DECISION DELEGATED TO HEAD OF PLANNING

Application No: H17-0485-25 **Applicant:** Mr H Brown
Proposal: Conversion of agricultural building into dwelling
Location: Rear Of The Chestnuts Reservoir Road Surfleet
Terminal Date: 16th July 2025

CASE OFFICER ASSESSMENT

EXISTING FLOOR PLAN

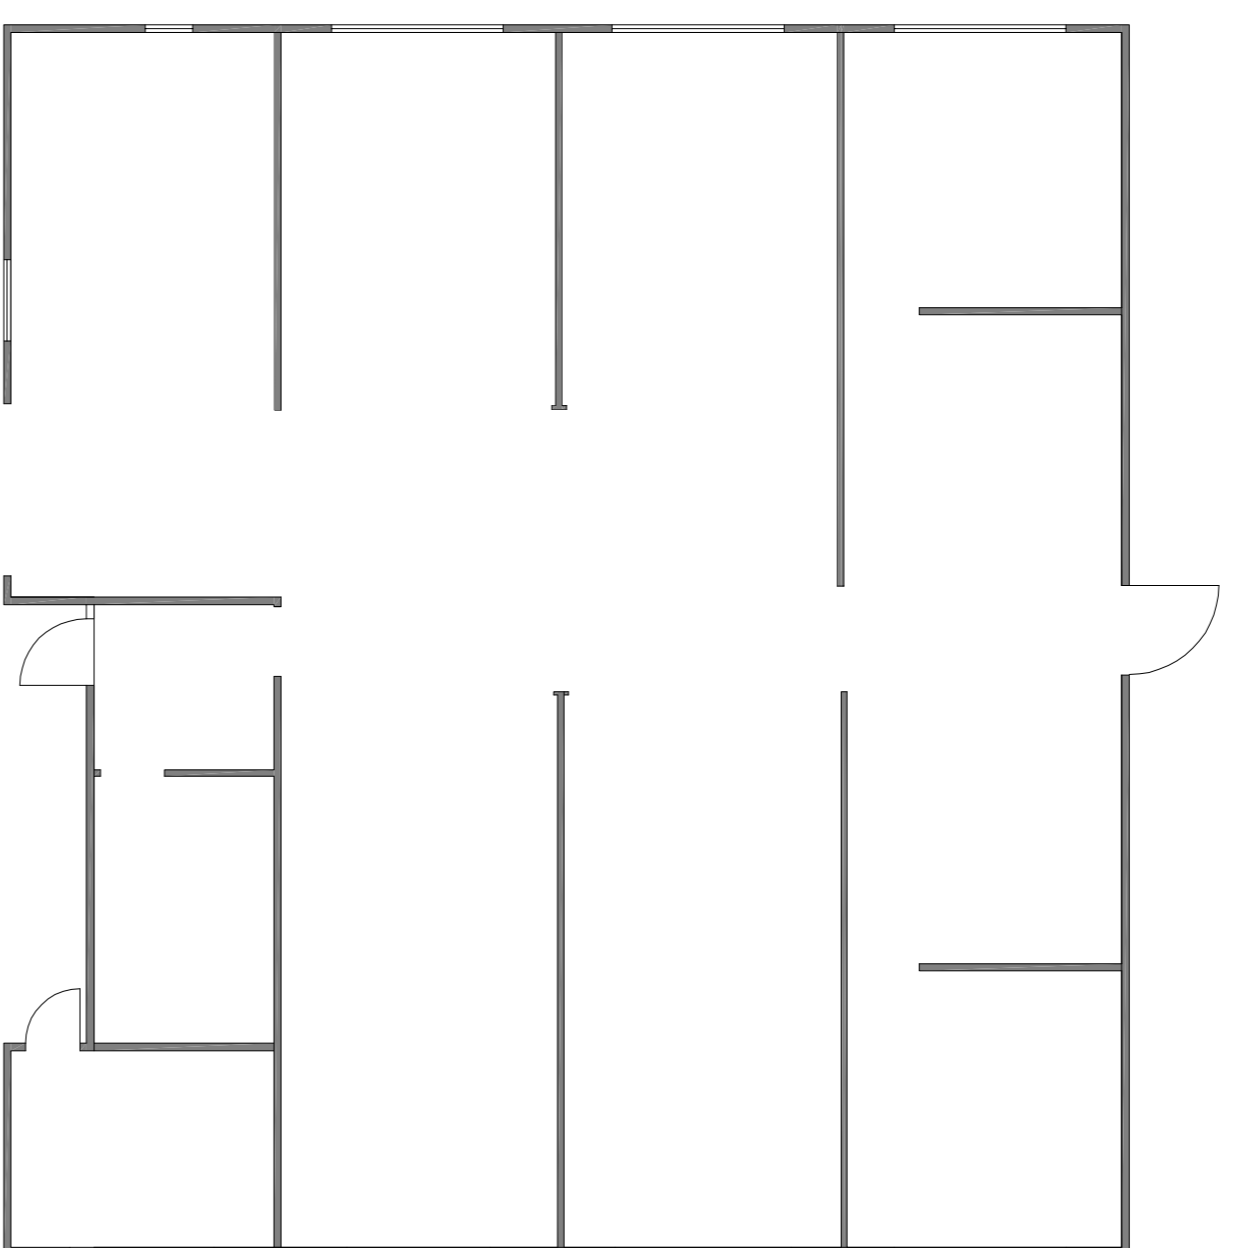
The proposal is to make changes to an existing building on site to form a two bedroom dwelling with access from Reservoir Road, the access is long, it is made up to appropriate widths. The building is very low at the eaves (circa 1.6m) and the design includes voids to remove unusable floor space from the dwelling.

PROPOSED FLOOR PLAN

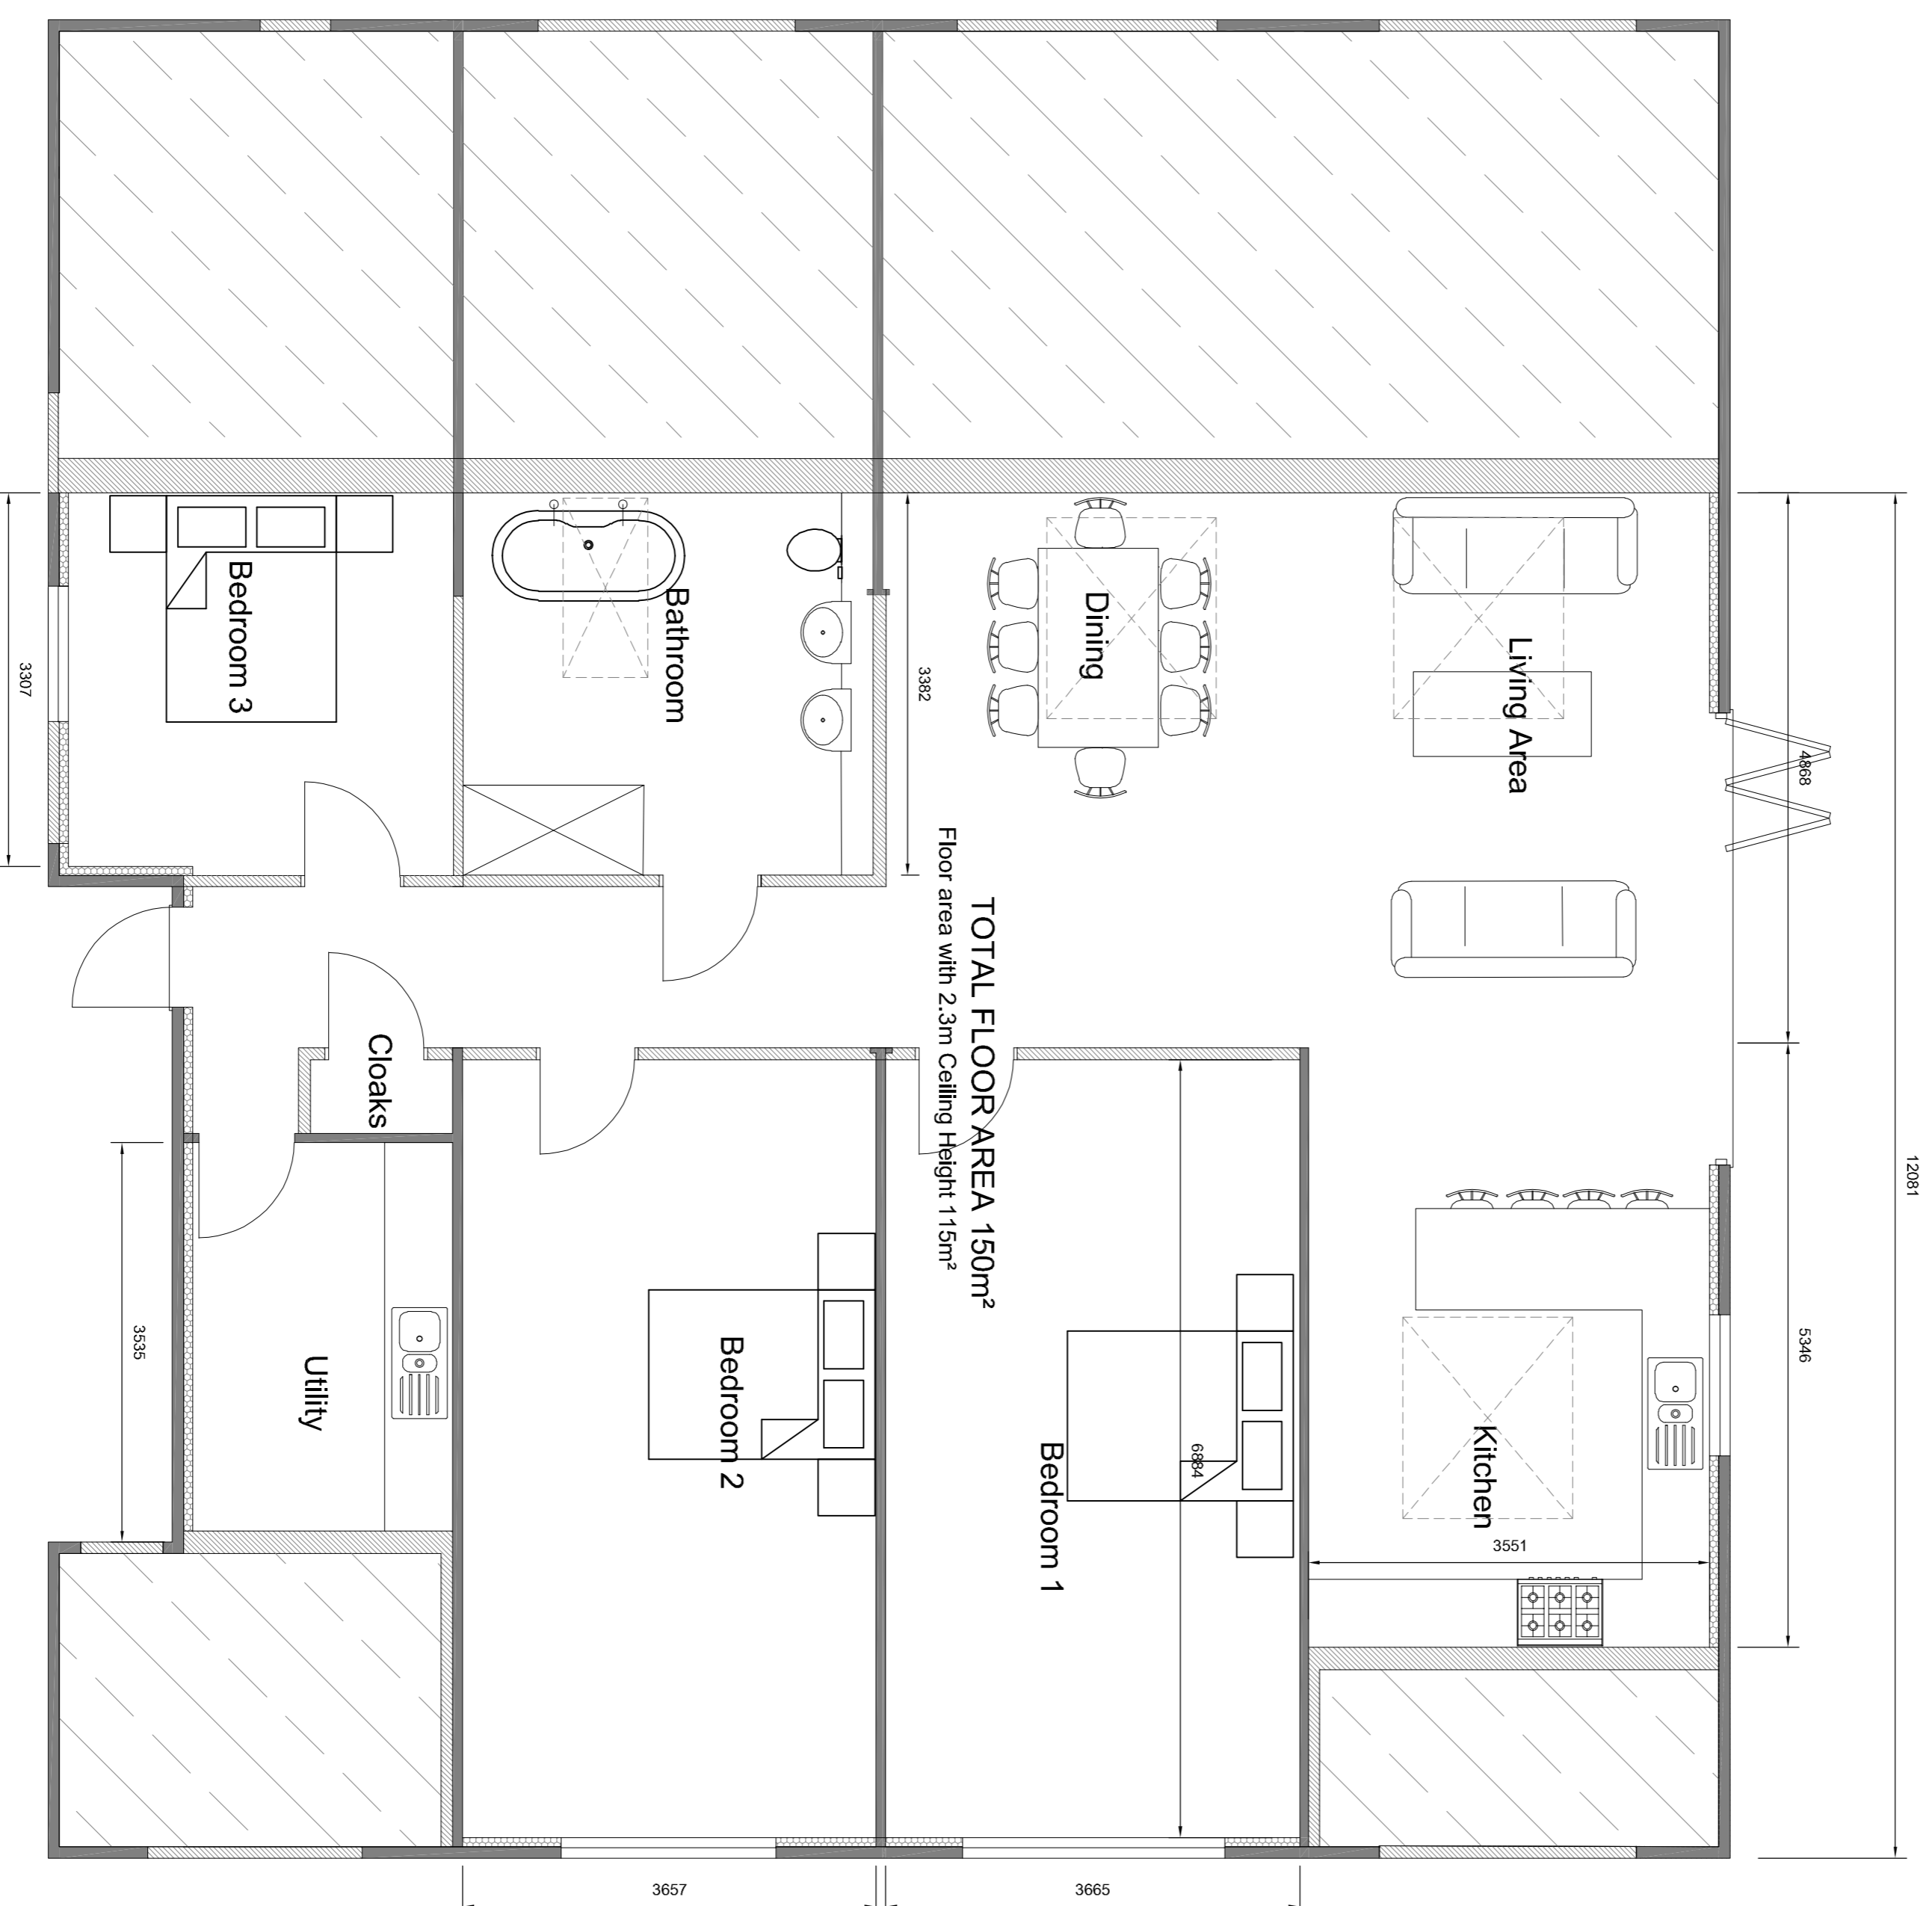
The eaves of the structure are low, the applicant has described on floor plan that 115sqm would have a 2.3m roof height. The floor plans show that internal walls are positioned to create voids.

The proposal is subject to Nationally Described Space Standards. The proposal is for a 2 bedroom house and should have an internal floor area of 70sqm. The walls at the measure eaves circa 1.6m on plan and part f of the space standards are relevant, they state:

It is likely then that despite the low amount of headroom in parts of the proposal (including the bedrooms) the development could meet with NDSS, in accordance with the plans submitted. However, should the proposal be required to raise FFLs due to flood risk, it is unlikely that NDSS could be met, therefore prior approval would be required on these grounds, in order to demonstrate that NDSS can be met alongside evidencing flood appropriate dwelling, with ground levels information provided.
